OBERON COUNCIL

Our Ref: PO36-124 JB:JB

7 September 2016

I refer to Development Application (SSD 7016) for the Borg Panels Timber Processing Facility Expansion, located at 124 Lowes Mount Road, Oberon.

Drawing
CONVEYOR, AWNING & CARPARK
(SHT 1)

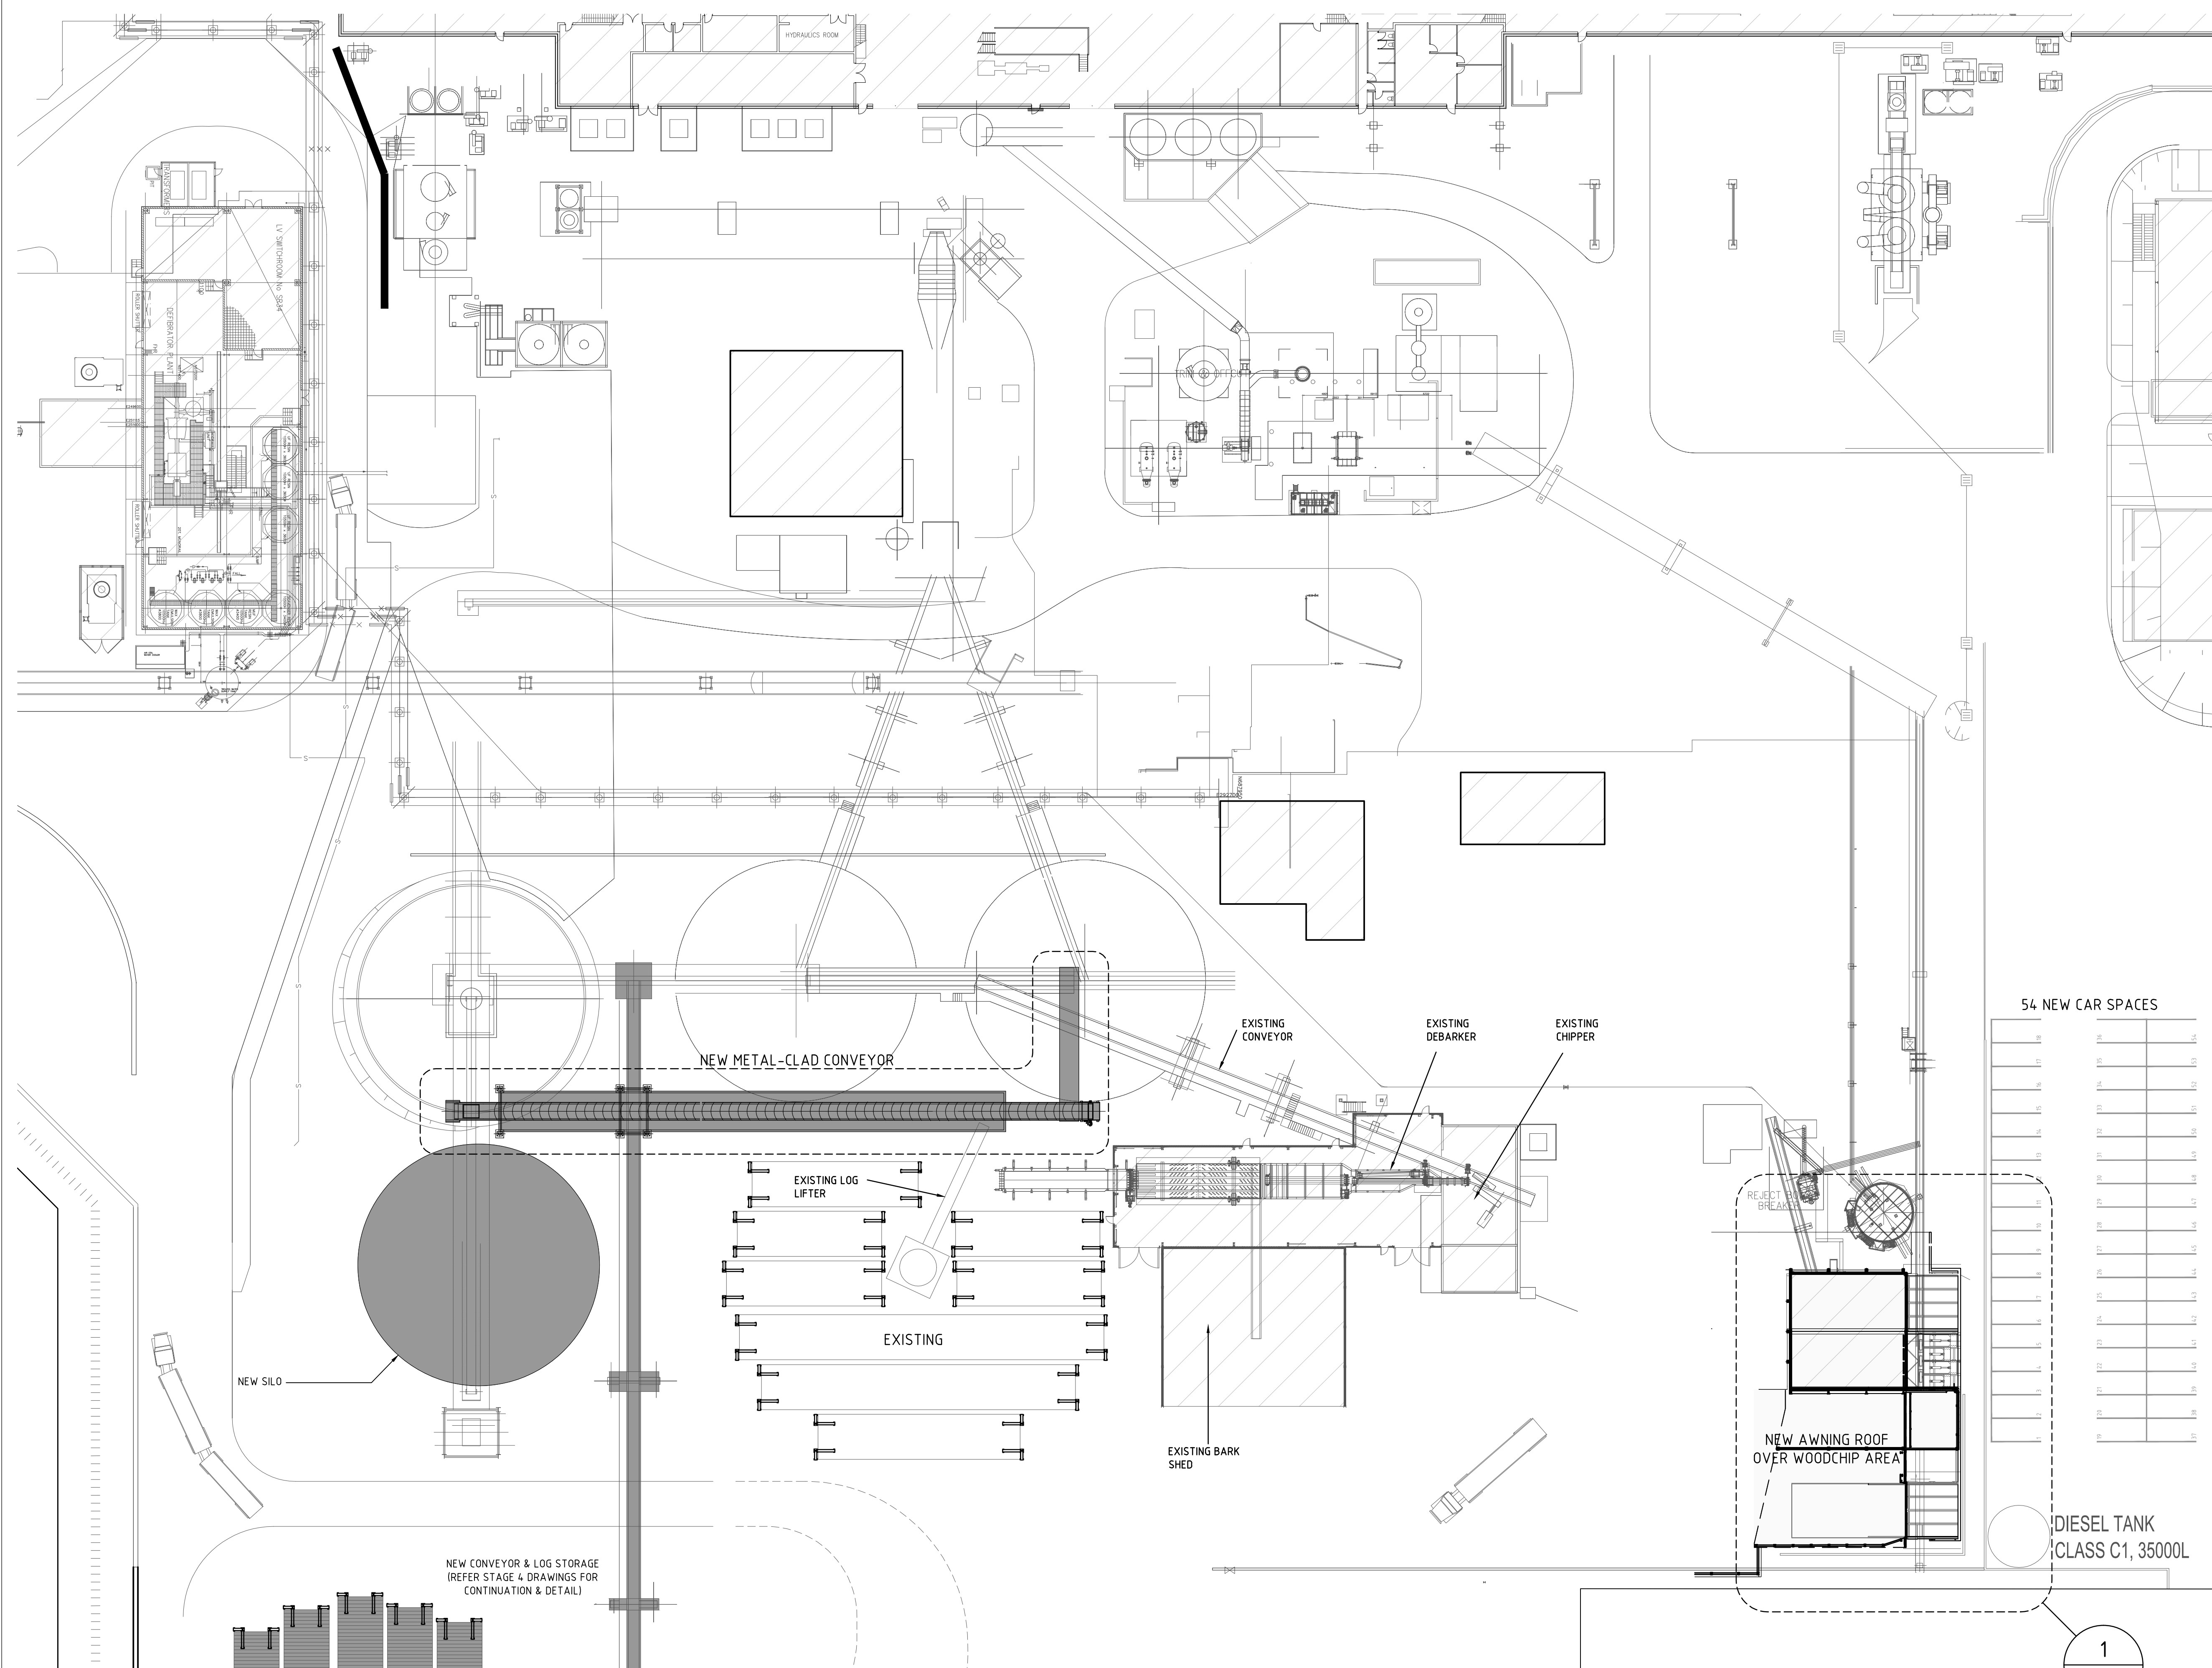
4. The information provided does not fully articulate the intended use for the hard stand areas identified as area 30 and 31, are these areas designated for car parking or for storage of products? Evidence needs to be provided to minimise and perceived impacts.
